CITY OF ALBUQUERQUE

April 24, 2023

RE: Loma Linda CC Gym Addition
Tr 2-A-1 Plat of Tracts 1-A & 2-A-1 Cactus/Shalit Parcel
1512 Yale Blvd SE ABQ NM 87106
Grading & Drainage Plan
Engineer's Stamp Date: 2/7/2023
Hydrology File: L16D025

Based upon the information provided in your resubmittal received 4/12/2023, the Grading plan is **not approved** for the Building Permit. The following comments need to be addressed for approval of the above referenced project.

DRAWING TITLE: SITE GRADING

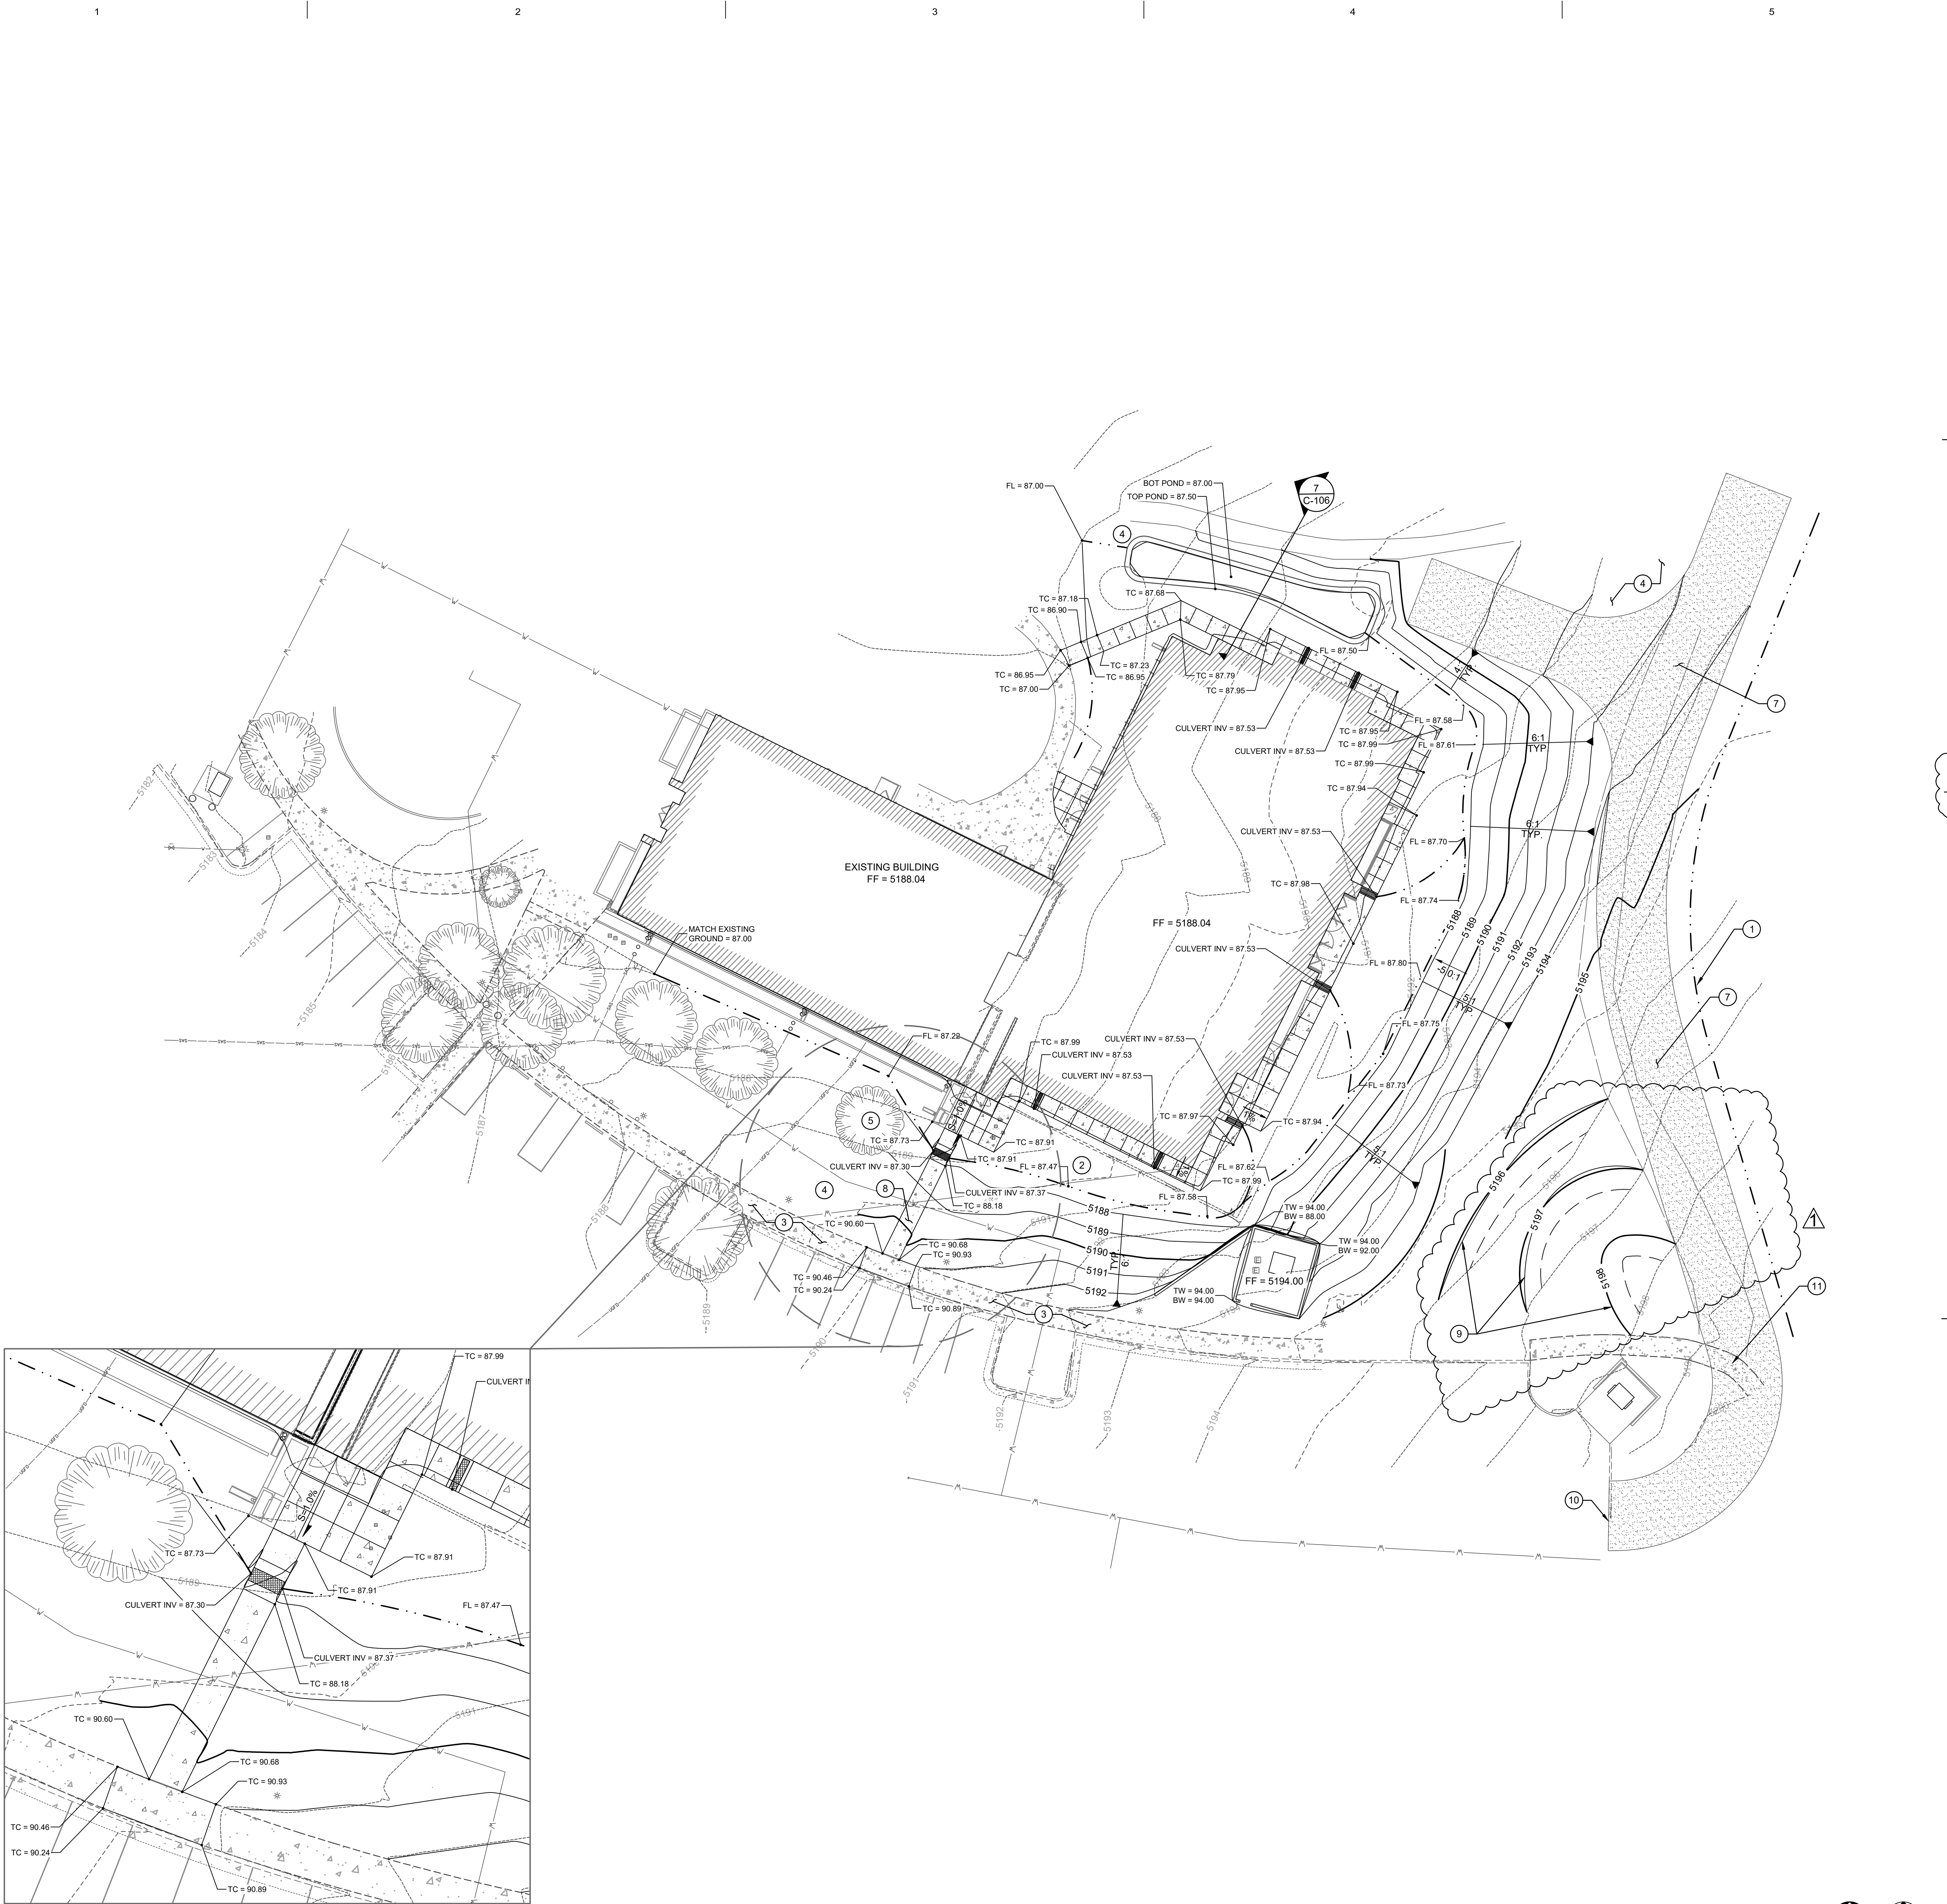
1. Please add vicinity map, FIRM map and bench mark on the plan.
2. Sheet C-103, Grading Note #1: Change sheet C-105 to C-106. Note #9: Fix the discrepancies between sheet C-103 & sheet C-104.
3. Add proposed contour elevations on the stormwater quality retention area on sheets C104 & C-104.
